**Project name:**  
Thurrock Flexible Power Generation  
Development

# Briefing Note –Thurrock Causeway Outline Design for DCO Response to Technical Comment

The PoTLL's response includes a Technical Design Note by Hydrock, "Geotechnical Engineering Assessment of the Proposed Statera Causeway, Tilbury" Rev 2, dated 17 May 2021. This AECOM technical note provides commentary on the Hydrock Technical Design Note.

Figure 2 Typical cross section of Causeway structure

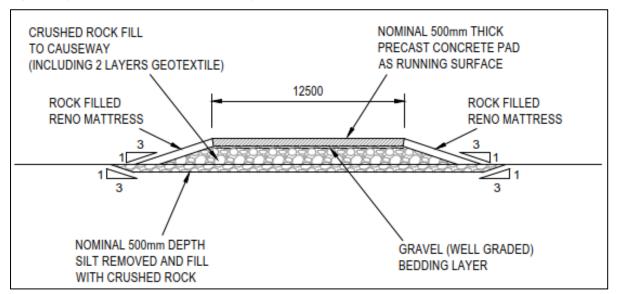
**Comment 9** - The current assumption to construct 1:3 side slopes for the causeway is questioned by AECOM, the concept designer. There is currently no ground investigation data to justify whether these slope gradients can be constructed at all. As there is no geotechnical data available no stability analyses can be carried out to support the conceptual design of the causeway side slopes.

## Response

As Comment 1, AECOM has undertaken an outline stability analysis of the causeway, based on the information available and assumptions, based on previous knowledge of similar sites including our work on the London Gateway Port project and is considered sufficient for DCO purposes, noting that as Hydrock state for the developed design a desk study and detailed ground investigation will be required to provide appropriate geotechnical and geoenvironmental parameters for the design of the causeway and berthing area.

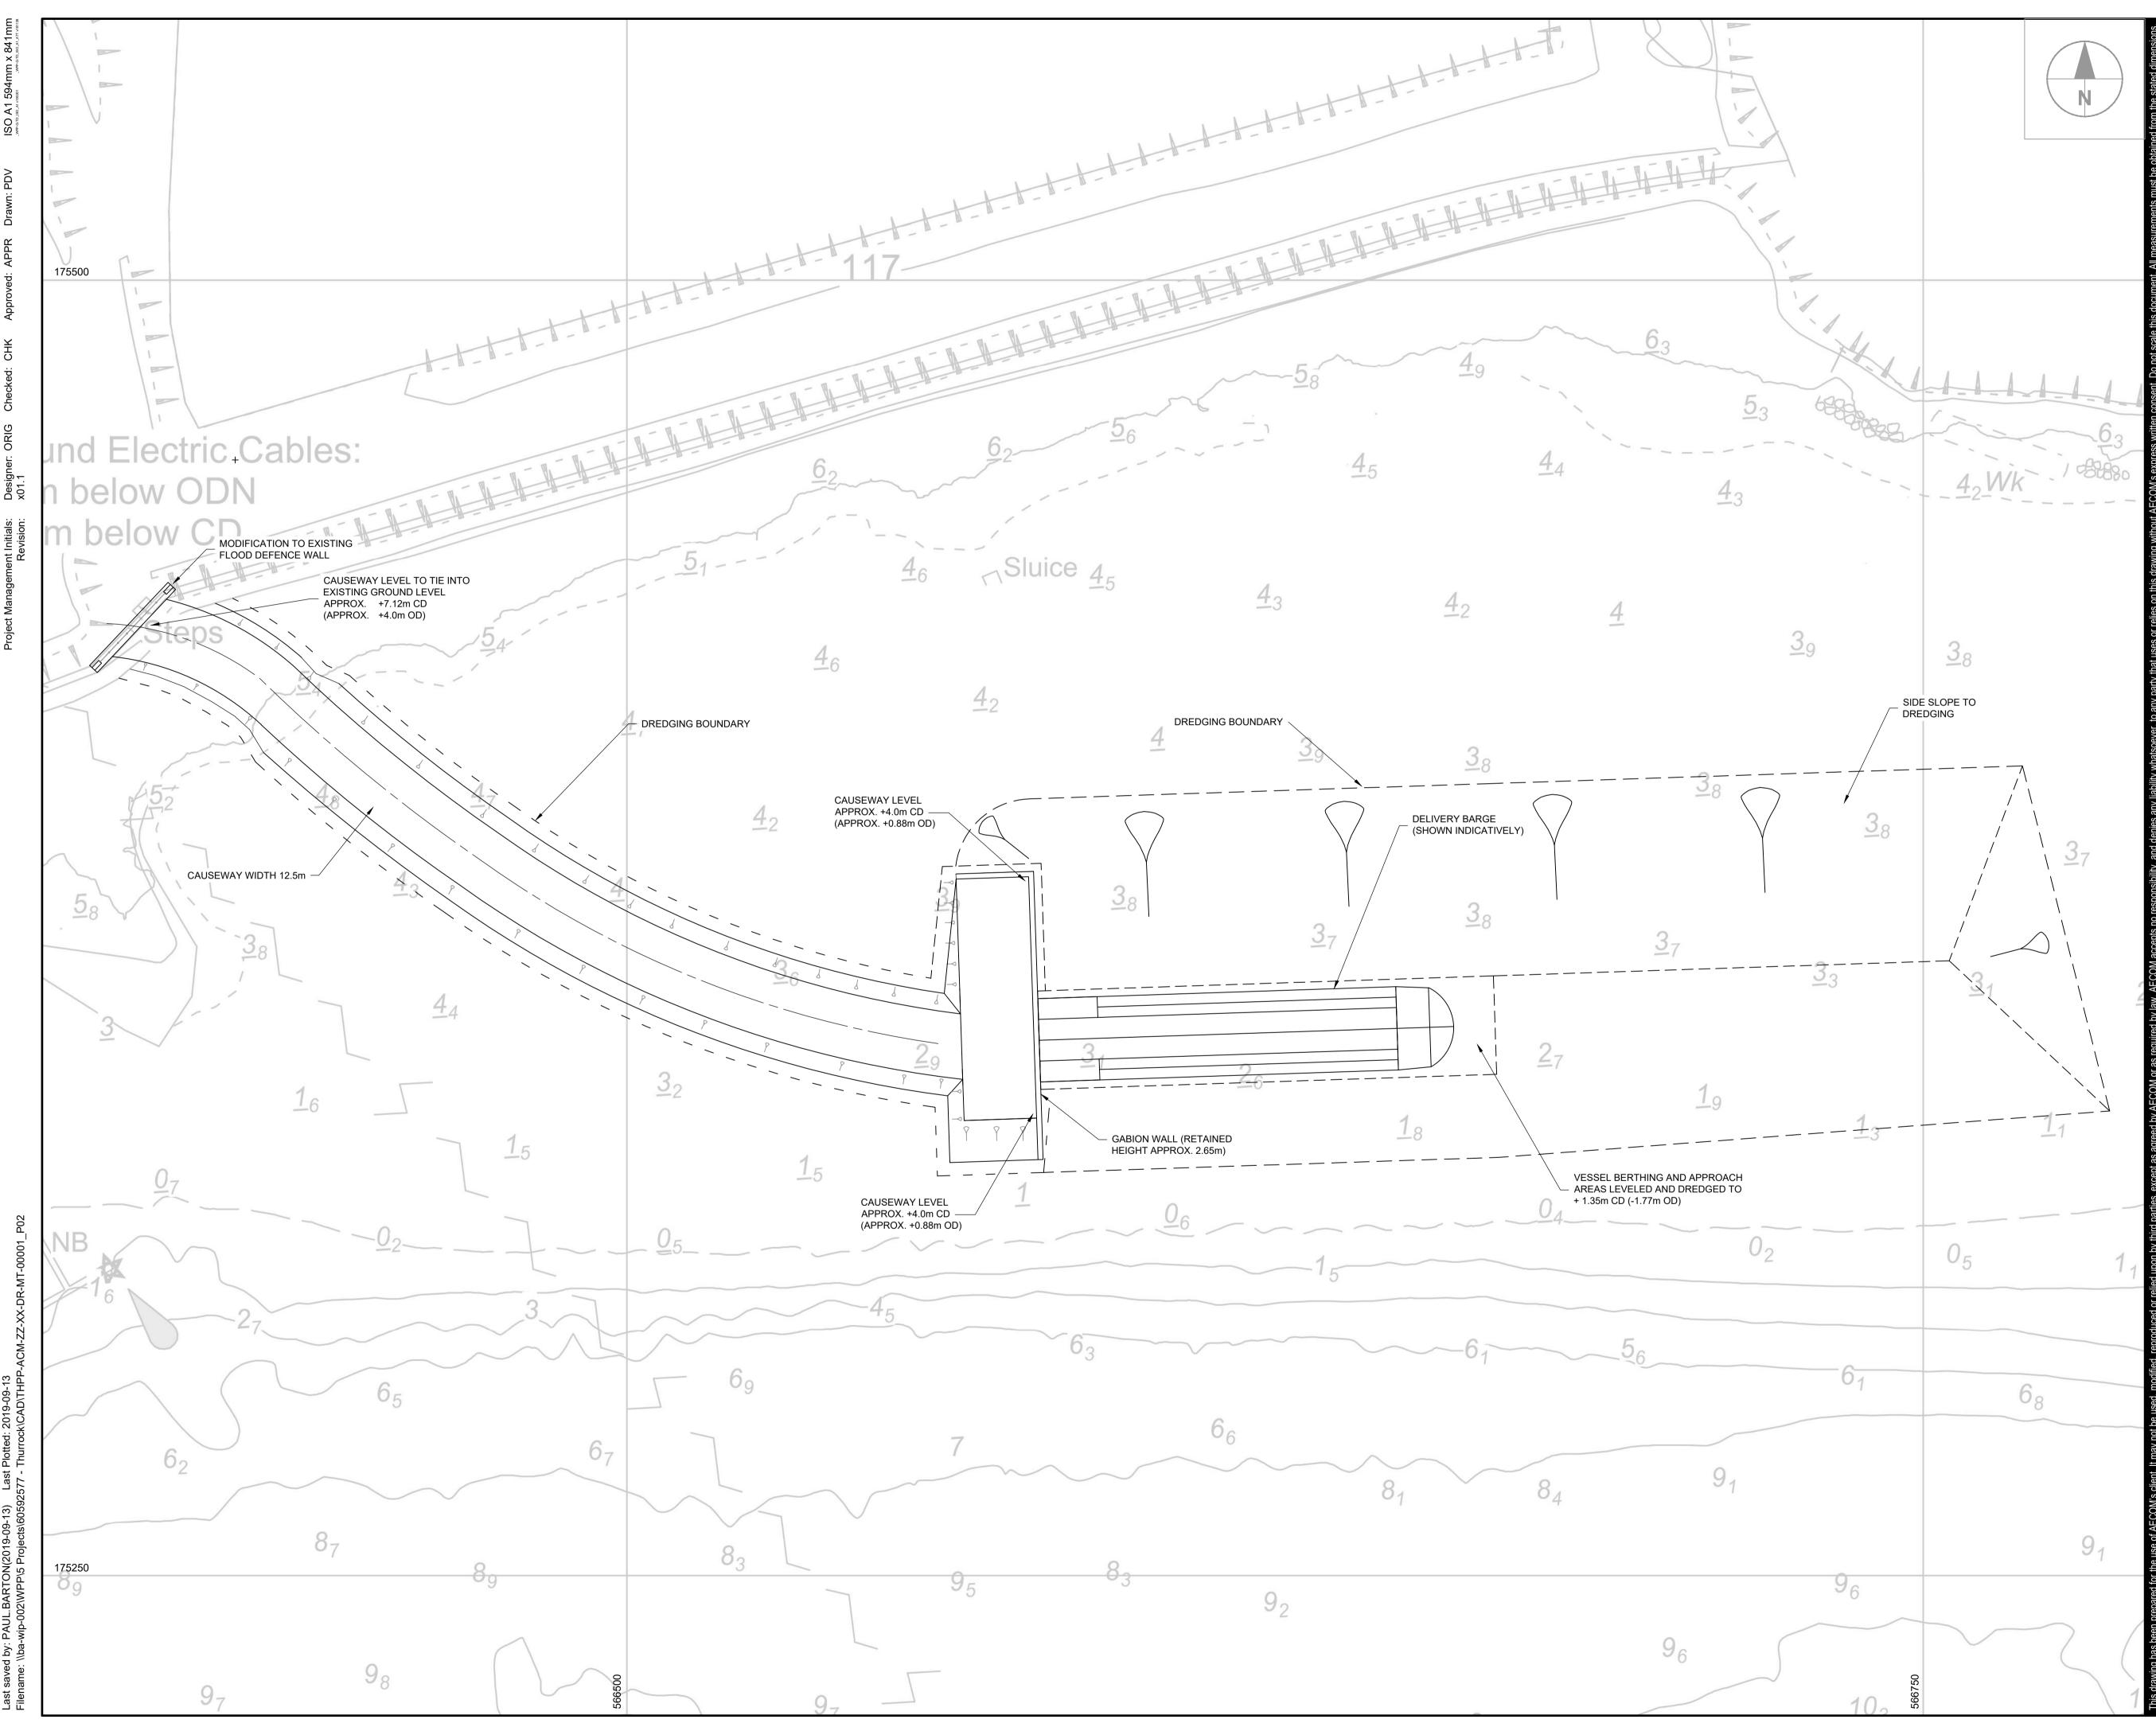
**Comment 8** - It is clear from the conceptual design report that there is currently no understanding of whether ground improvement techniques will be required as part of the construction process. This reflects the lack of information on ground conditions for the site area. The construction process described in the conceptual design report is vague and no specific methodology or material specification and measures to control the long-term settlement of the causeway have been provided. It is important that the design considers the long-term performance of the causeway to ensure that cranes and vehicles intended to use the causeway can function properly and safely without the need for further remedial works.

As Comment 1, noting that ground improvement may be required, but is not expected to change the footprint of the causeway. The transportation of AILs requires a level roadway, that is routinely graded during operation, such that the effects of settlement are controlled.
